## NSW RURAL FIRE SERVICE

Your reference: SSD8368  
Our reference: D17/1299  
DA17042707009AB

**Agency Comment: Environmental Impact Assessment (SSD8368) Grafton Correctional Centre  
313 Avenue Road Lavadia**

Figure 4-1 | Bushfire protection measures

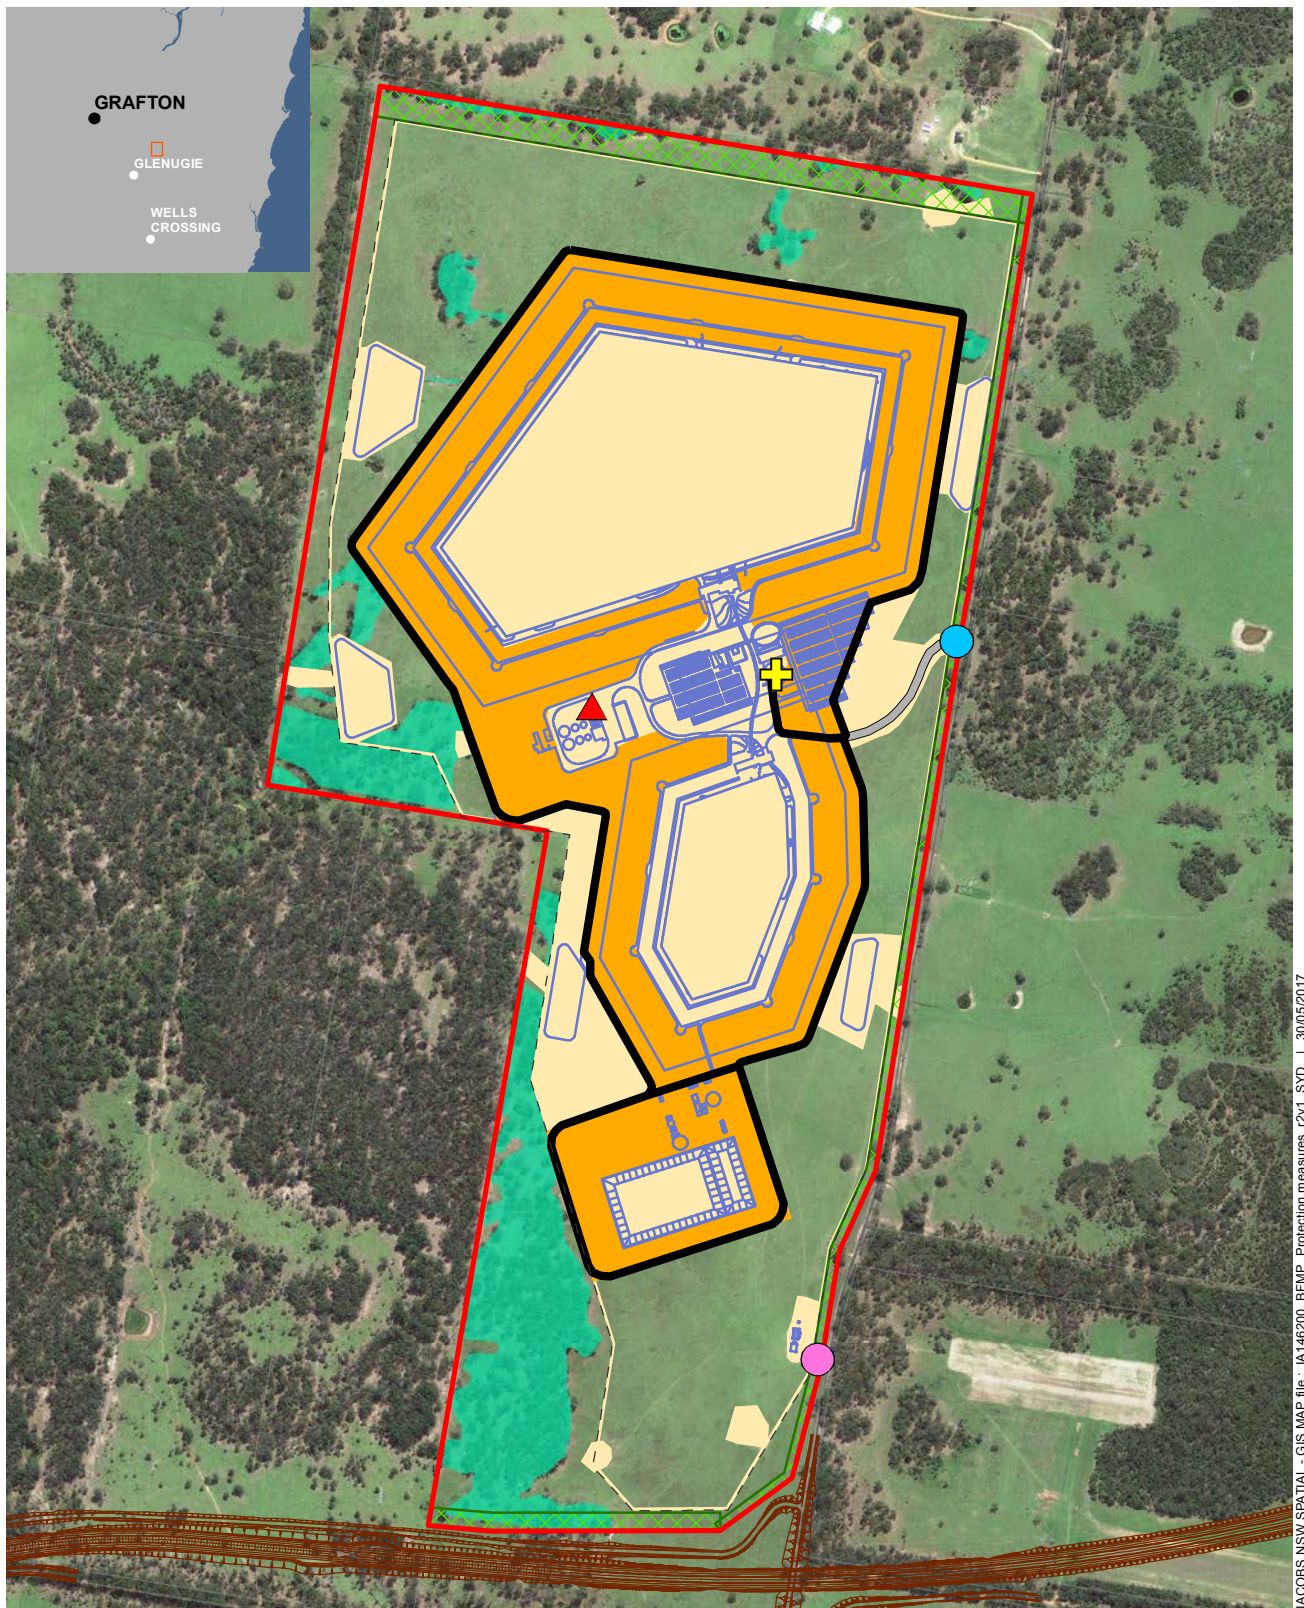
1. The proposed asset protection zones as detailed in Appendix 11 of the EIS prepared by BBC Consulting Planners, dated June 2017 (documented on figure 4.1 Bushfire Protection measures page 20 Bushfire Assessment report dated 30 May 2017) shall include the proposed internal access road and the stage 2 clearing footprint associated with that internal access road.
